Title: STAGE 1 ROAD SAFETY AUDIT

Proposed Residential Development at Hacketstown, Skerries.

Client: DBFL/Land Development Agency

Report reference: 1389R01

**PLAN OF TRAFFIC PLATFORM**  
SCALE 1:100

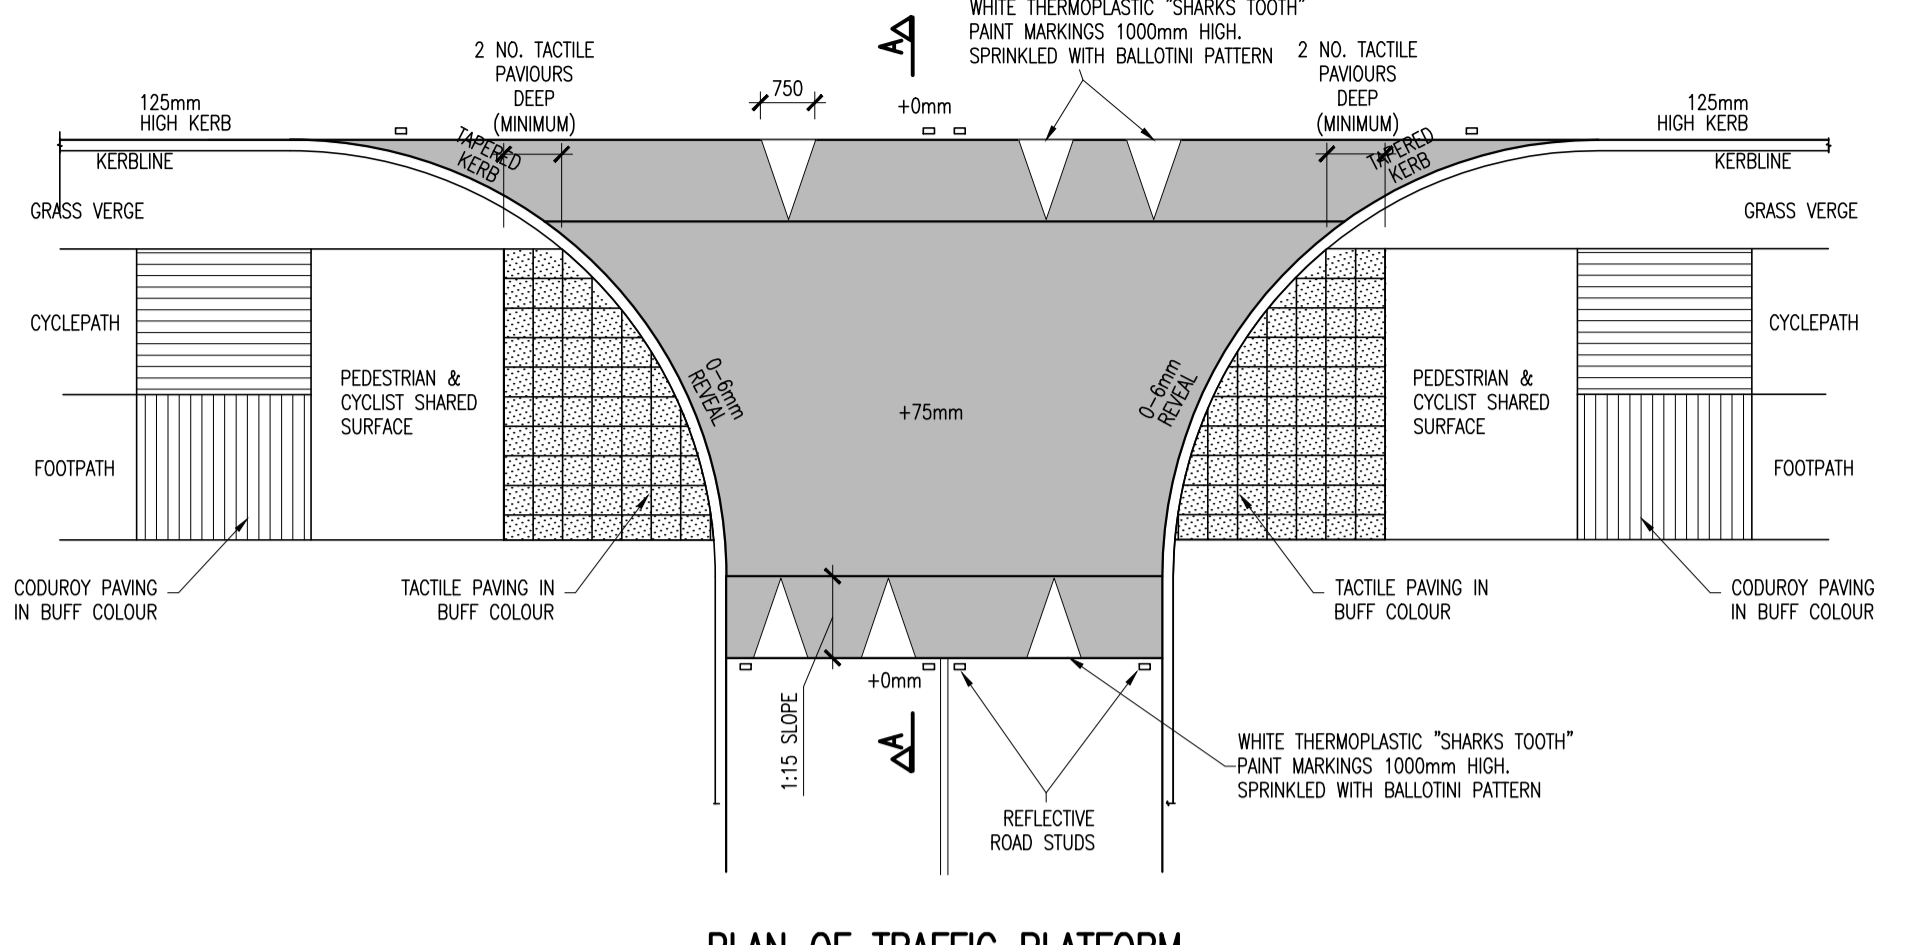
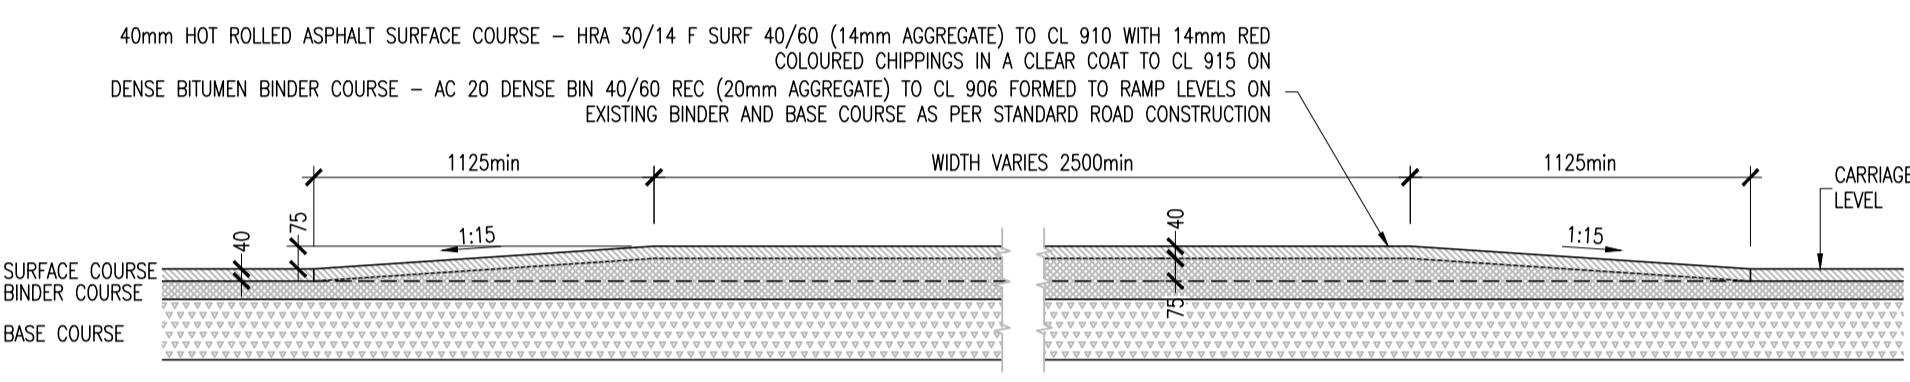
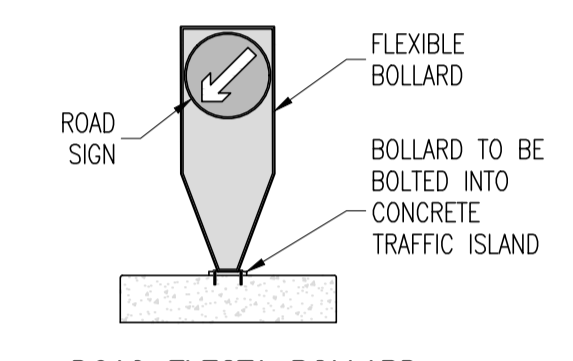
It is proposed to provide raised tables throughout the development including at sharp changes in direction. There is a risk that drivers will cut the corners and mount the adjacent verge/footpath if the raised tables are at the same height. This could be a risk for pedestrians.

It is recommended that suitable vertical segregation between the top of the raised table and the top of the kerbs be provided.

| Paragraph No. in Safety Audit Report | Problem accepted (yes/no) | Recommended measure accepted (yes/no) | Alternative measures (describe) | Alternative measures accepted by Auditors (Yes/No) |
|--------------------------------------|---------------------------|---------------------------------------|--|--|
| 3.5 | Yes | Yes | | |

**UNCONTROLLED DISHED CROSSING WITH TACTILE PAVING**  
SCALE 1:50

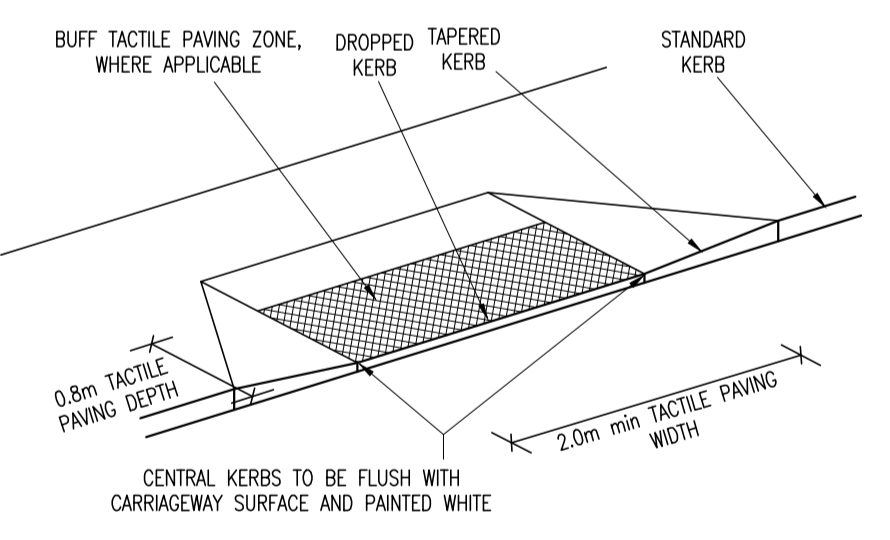
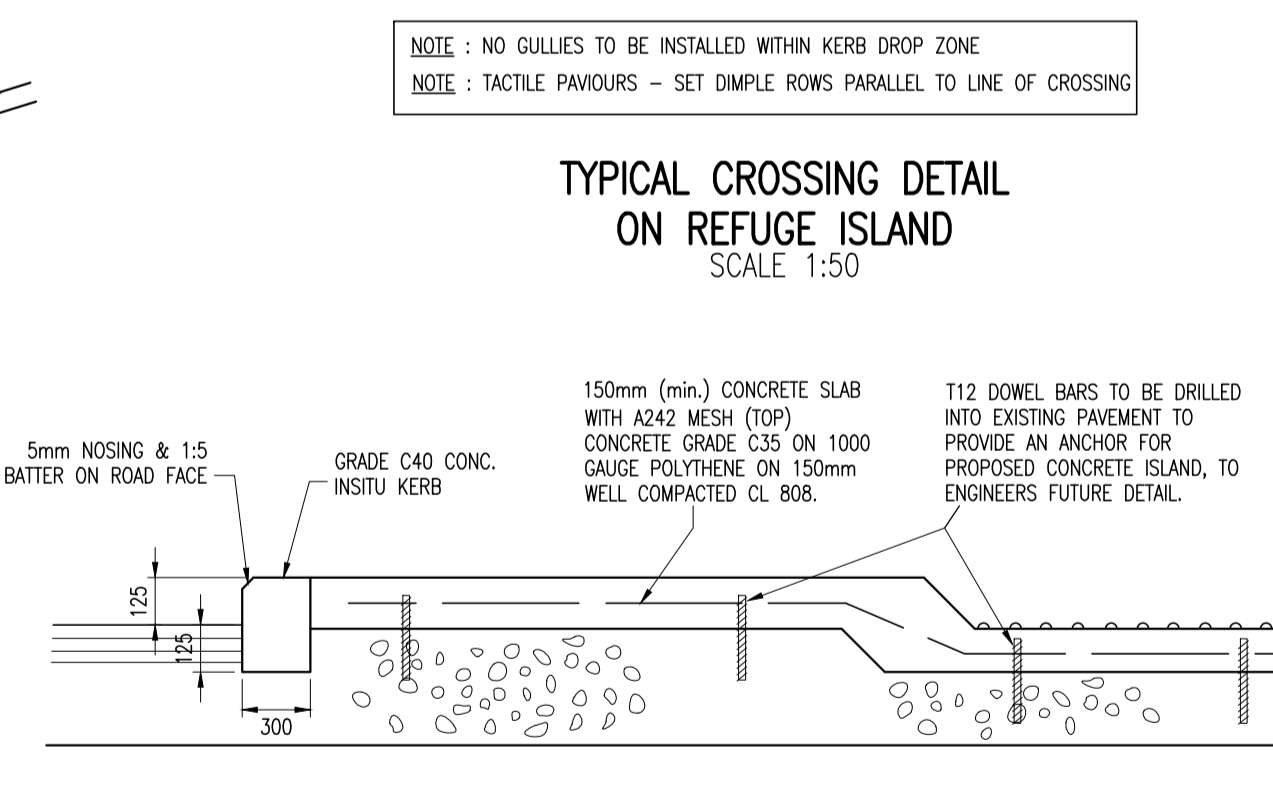
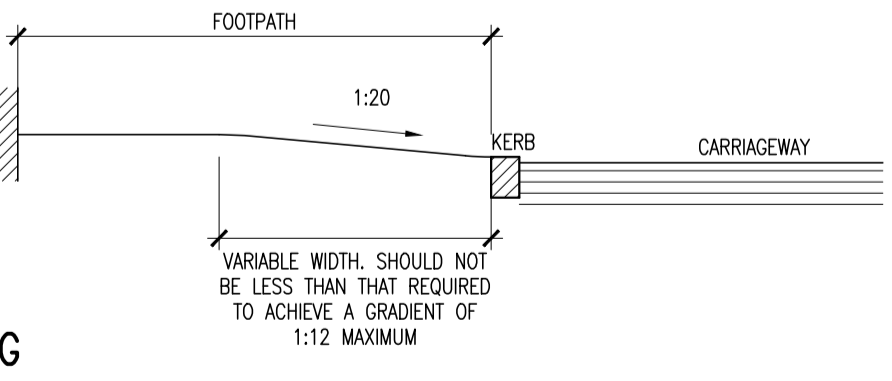
The raised tables throughout the development generally have associated uncontrolled pedestrian crossings. It is unclear if the crossings are dished at the tactile paving only or across the entire footpath width. If there are areas where the footpath is flush with the raised table and without tactile paving a blind or partially

sighted pedestrian may inadvertently enter the carriageway. This could lead to collisions with passing vehicles. In addition, some pedestrian crossing locations appear to be narrow (three tiles i.e. 1200mm) which may not cater for the volume of users.

It is recommended that tactile paving be provided over the entire width of dropped kerbs/flush kerbs with the raised tables and that the area of dropped kerb be of sufficient width to match the demand.

| Paragraph No. in Safety Audit Report | Problem accepted (yes/no) | Recommended measure accepted (yes/no) | Alternative measures (describe) | Alternative measures accepted by Auditors (Yes/No) |
|--------------------------------------|---------------------------|---------------------------------------|--|--|
| 3.6 | Yes | Yes | | |

**TYPICAL EMBANKMENT DETAIL**  
SCALE N.T.S.

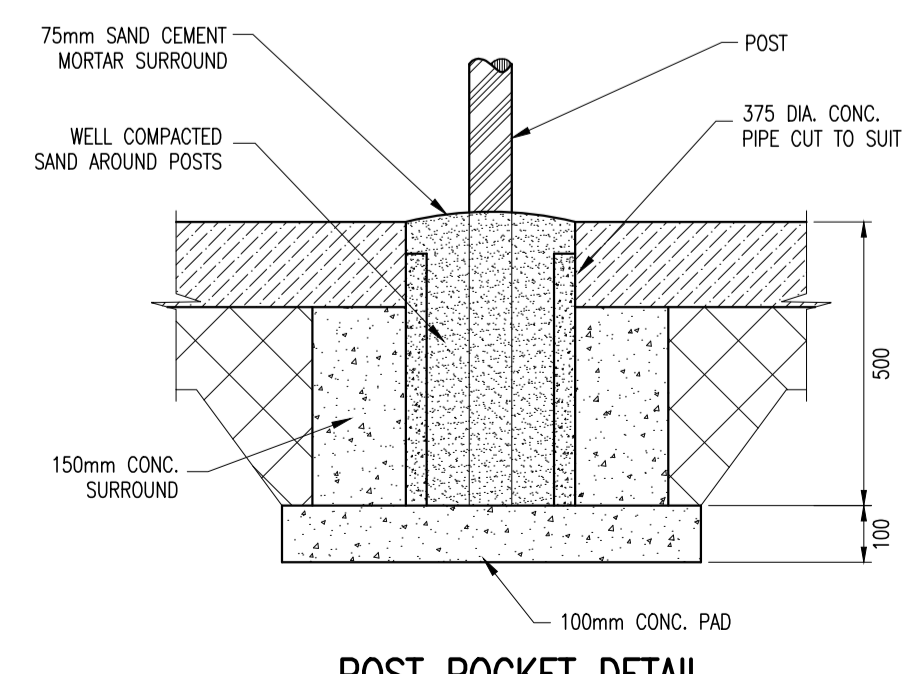
Details have not been provided of the section of road to be provided linking the proposed development to the main access road in Ballygossan Park. Given the topography of the site a bridge structure will likely be

required. There is a risk that errant vehicles could descent the height hazard and also a risk that vulnerable road users could fall from a height.

It is recommended suitable parapet railings/walls/restraint systems be provided which extend over the length of need.

| Paragraph No. in Safety Audit Report | Problem accepted (yes/no) | Recommended measure accepted (yes/no) | Alternative measures (describe) | Alternative measures accepted by Auditors (Yes/No) |
|--------------------------------------|---------------------------|---------------------------------------|--|--|
| 3.2 | Yes | No | The subject road link is to be constructed using an embankment with gently sloping sides (and rounded transitions) opposed to the alternative bridge structure option considered by the auditors. The gradient of the embankments side slopes varies (typically 1:7) however at its steepest position it will still be relatively shallow with a max fall of 1:5 with an overall the height difference of criteria 4.15m. The provision of this level of gradient with appropriate transitions and a height difference of less than 6m negates the need to provide the requested restraint system. | Yes |
